**Application Ref.:** F/5/20/PL  
**Applicant:** Ford Airfield Market  
**Proposal:** Reconfiguration of Ford Market, including revised market access, hardstanding for replacement vehicular parking and associated infrastructure, landscape, ancillary and site preparation works.  
**Location:** Ford Airfield Market Ford BN18 0FL

This representation has been prepared on behalf of Ford Energy from Waste Ltd. Ford Energy from Waste Ltd is a joint venture company owned by Viridor Waste Management Ltd and Grundon Waste Management Ltd, both significant waste management operators in the UK. Ford Energy from Waste Ltd is currently developing plans for an energy recovery facility on the strategic waste site allocated at Ford, currently occupied and operated by Grundon Waste Management Ltd. It is the intention to submit a planning application accompanied by an Environmental Statement to West Sussex County Council for determination in May this year.

Drawing Title
PROPOSED SITE PLAN

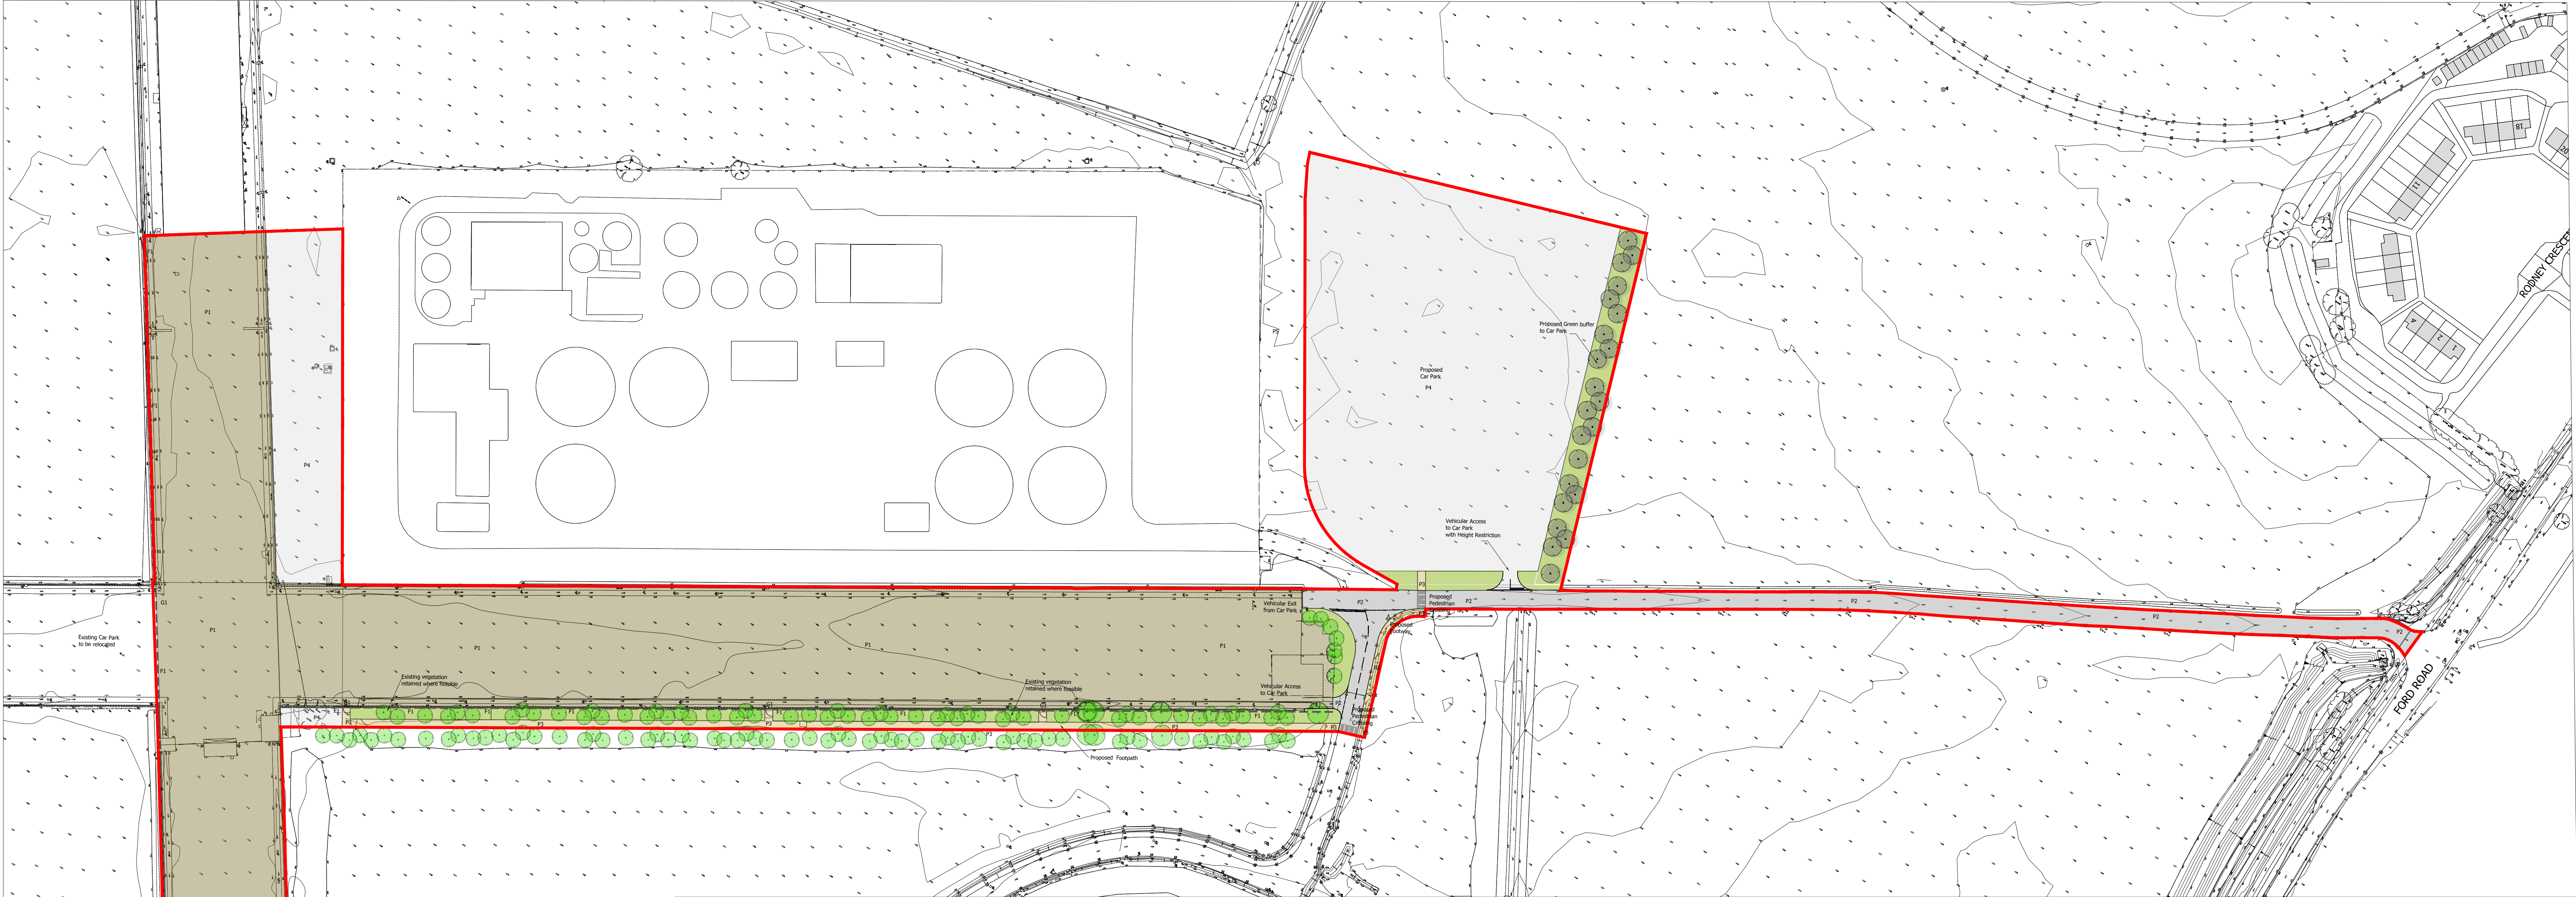
We note that the plans included in the planning application for the Ford Airfield Market reconfiguration do not show the Ford CTP new site access road.

We are also extremely concerned with the proposed layout for the market reconfiguration, and in particular the proposal for the new overflow car park. This would create a new access point along the Hunterford service road and a new pedestrian crossing in very close proximity to the access point to the Ford CTP site, with the associated issues of pedestrian safety and conflicts between vehicles entering the three strategic waste facilities outlined above and the users of the market.

- The proposed layout is reconfigured to provide an appropriate means of access to the overflow car park and main car park which takes into account existing traffic flows, vehicle types and visibility splays from existing strategic waste management facilities.
- A revised Transport Assessment is submitted which considers the correct baseline and potential cumulative impacts with other strategic waste management facilities.
